Ref: FG/143/14/HH.
Mr Karl Roberts.

18th October 2014.

TWO STOREY SIDE AND SINGLE STOREY REAR EXTENSION.
9 BROOK LANE. FERRING.

PROPOSED ELEVATIONS 1:50

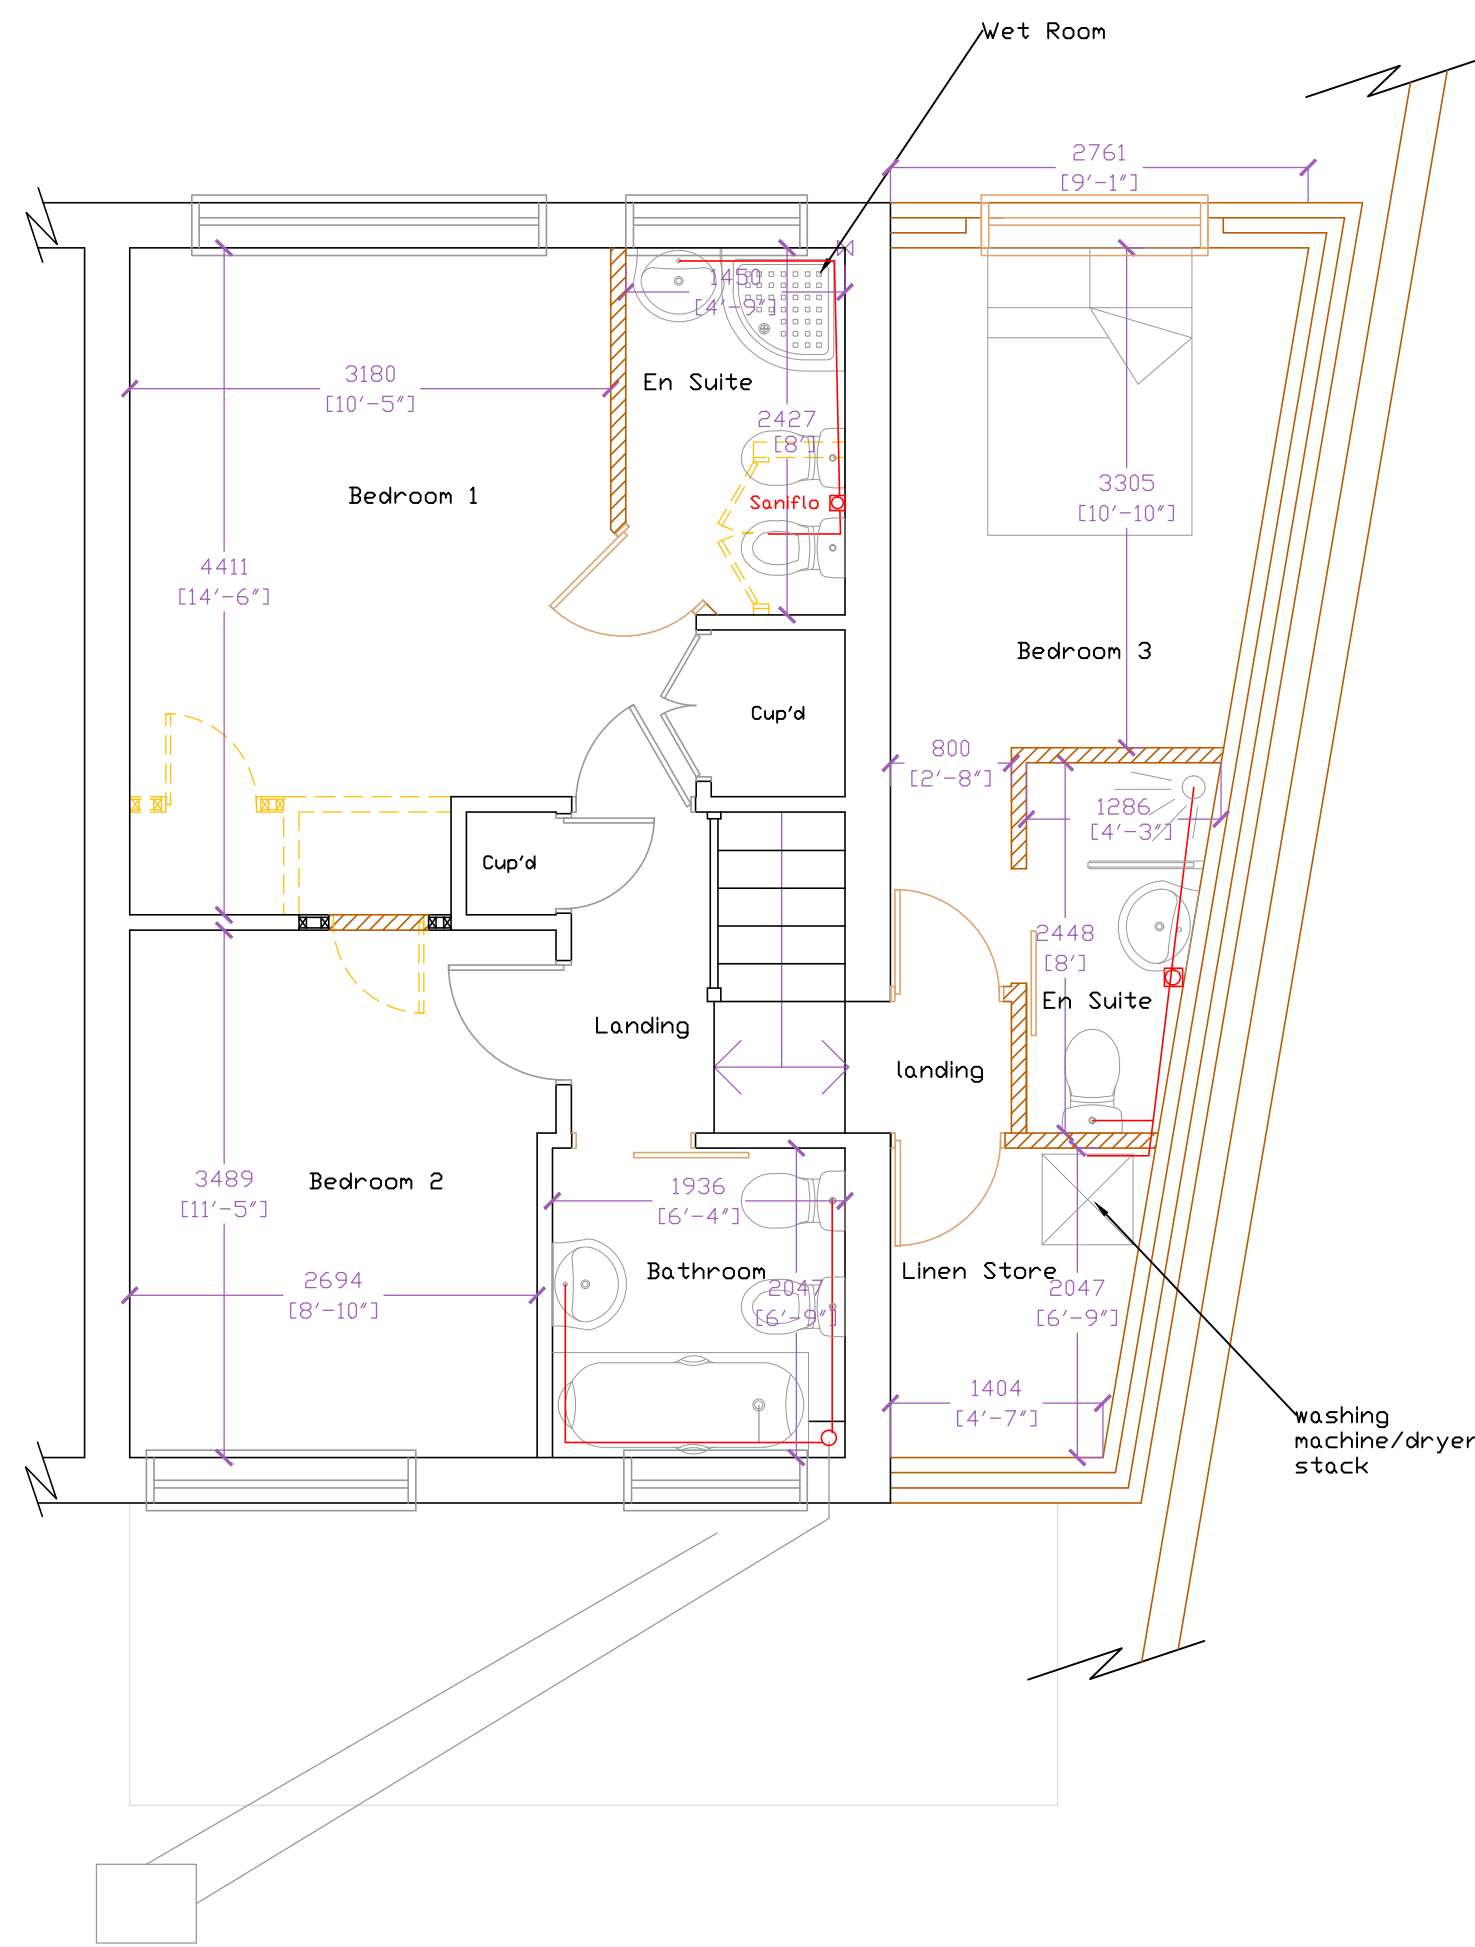
The rear extension is of course not a problem at all, but the two storey side extension will bring a full height gable wall much closer to my side courtyard, although there are no windows proposed so will not actually be overlooked.

PROPOSED FLOOR PLANS 1:50

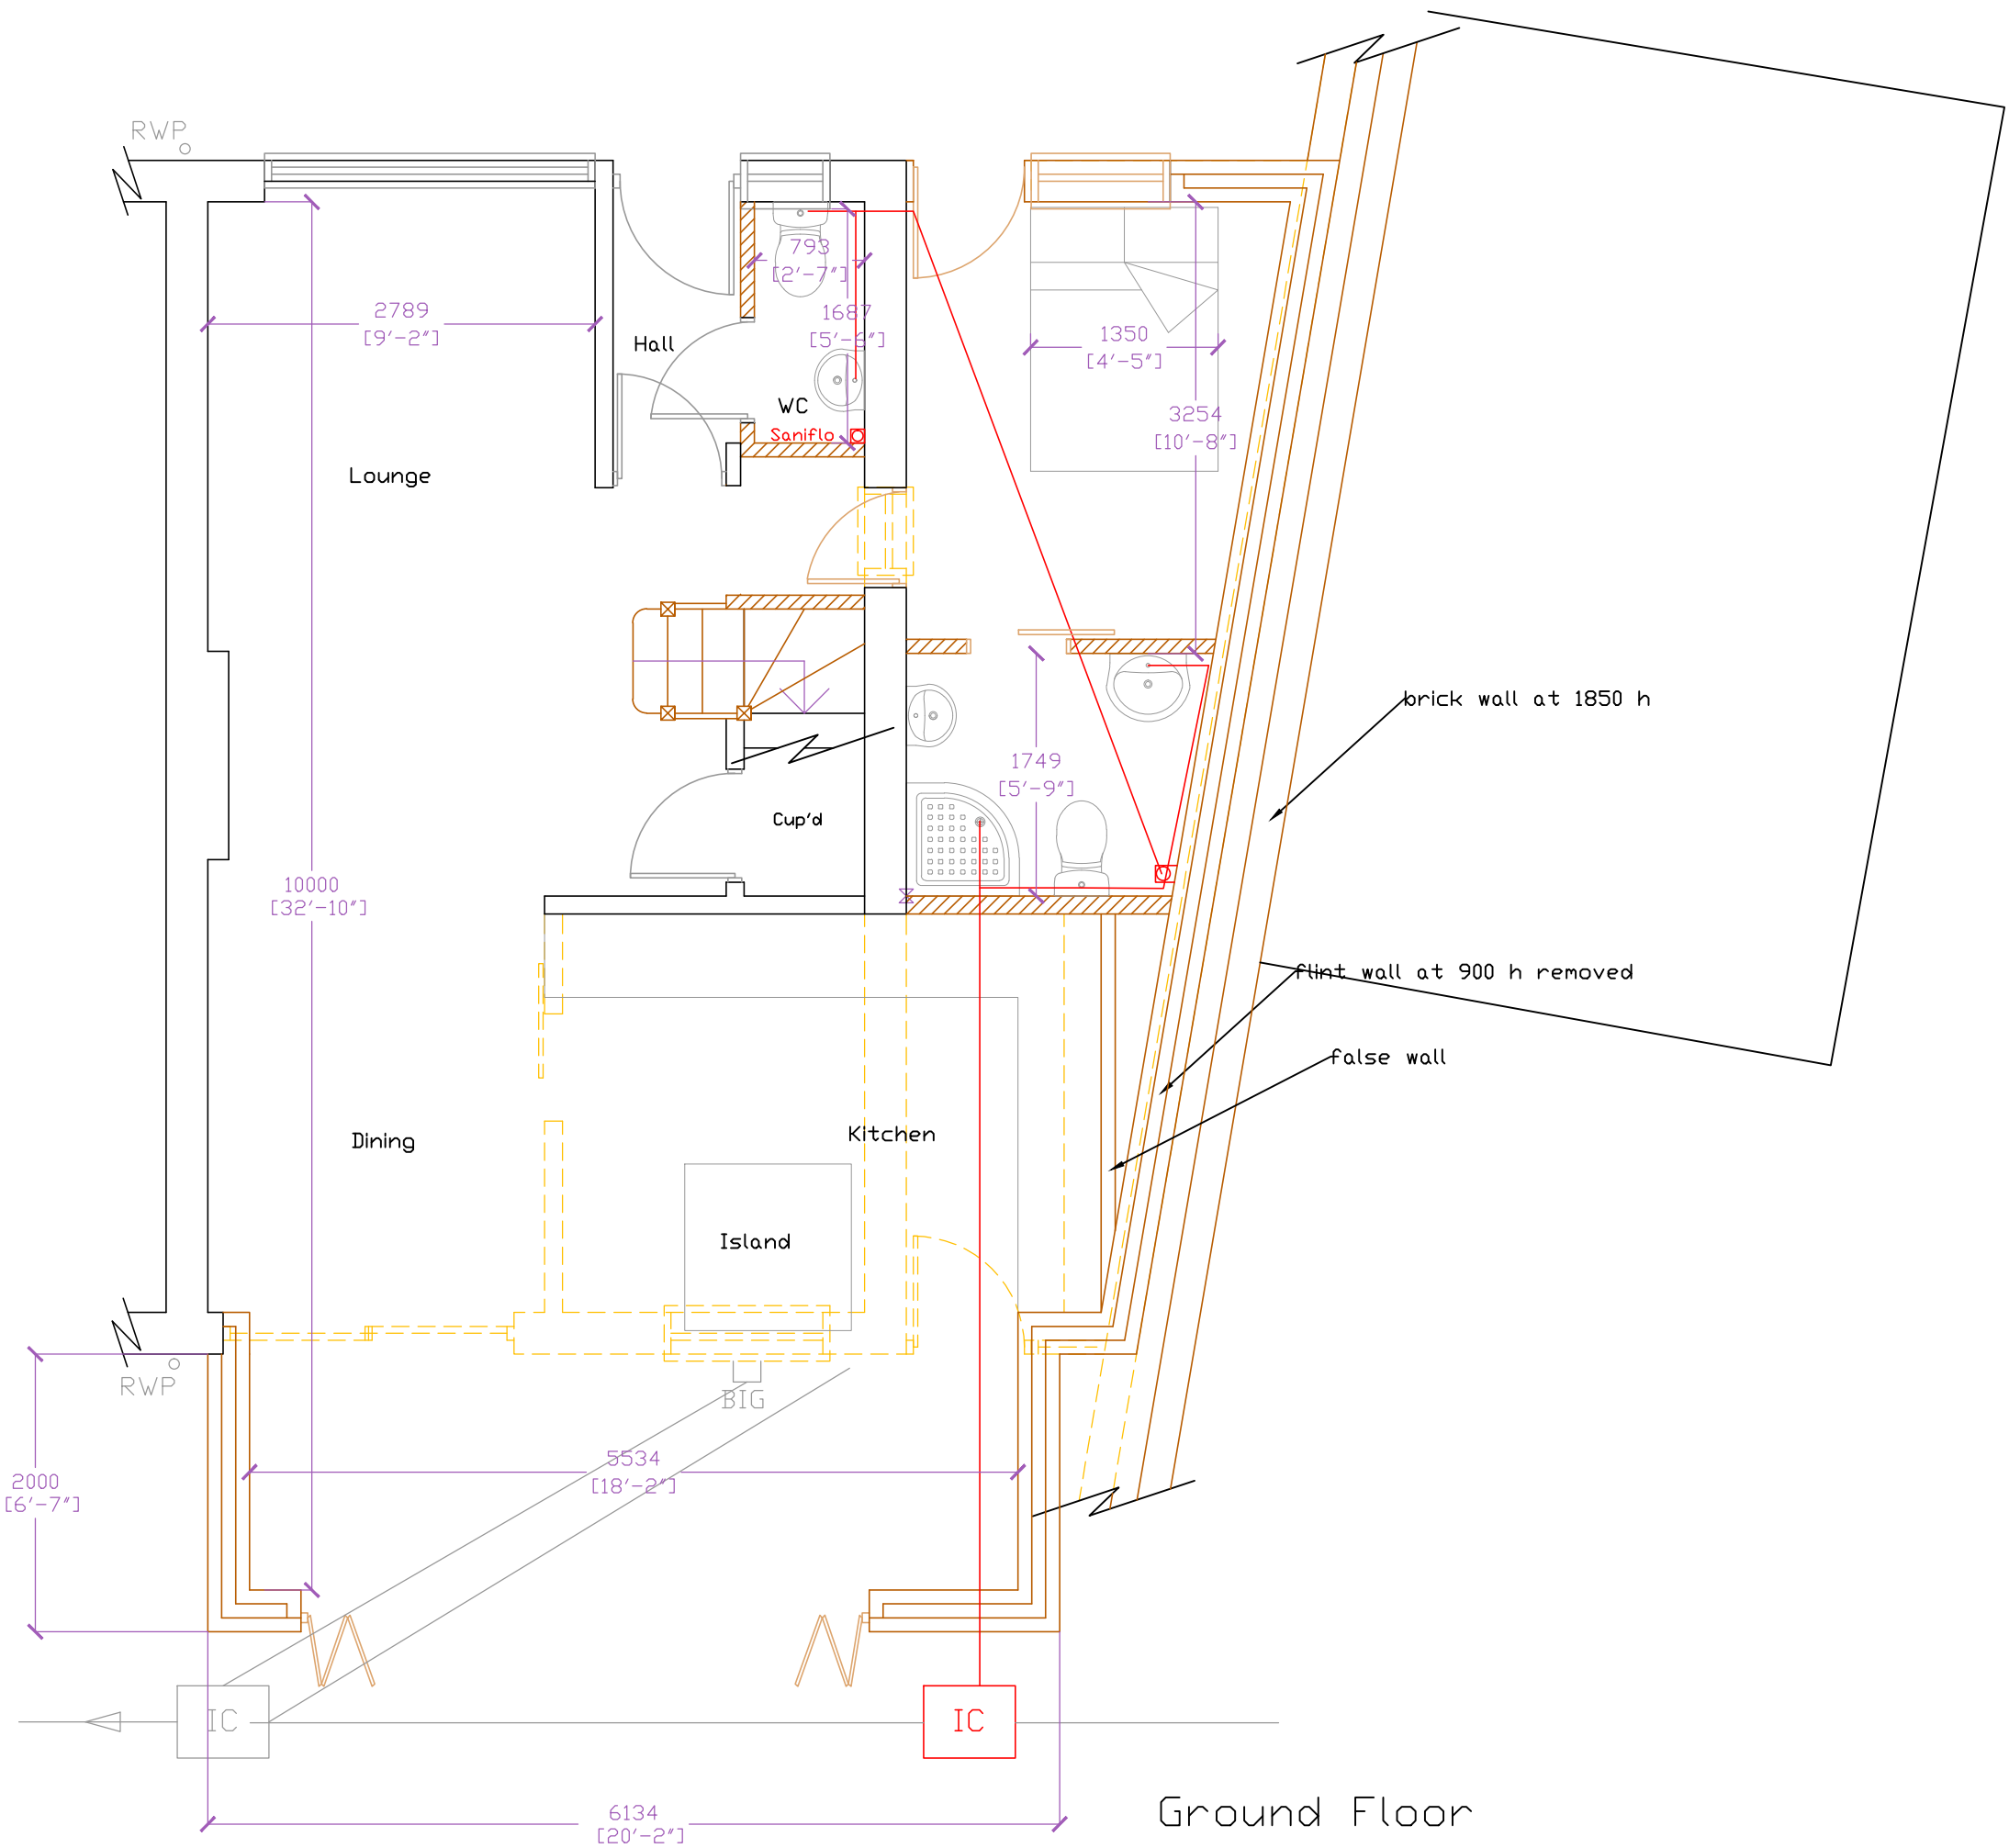
However, I do note that that the ground floor at the front of the side extension has been designed to provide a second and separate front entrance door to the new bedroom. This causes me to suspect that this additional entrance may lead to the new bedroom being used as a separate rental flatlet thereby increasing the dwellings occupancy, and of course with the corresponding increase in car parking adjacent to my property. IF NOT THEN WHY IS IT THERE?

I therefore register my objection to the proposal as designed and ask that this point be clarified, or a small redesign be carried out.
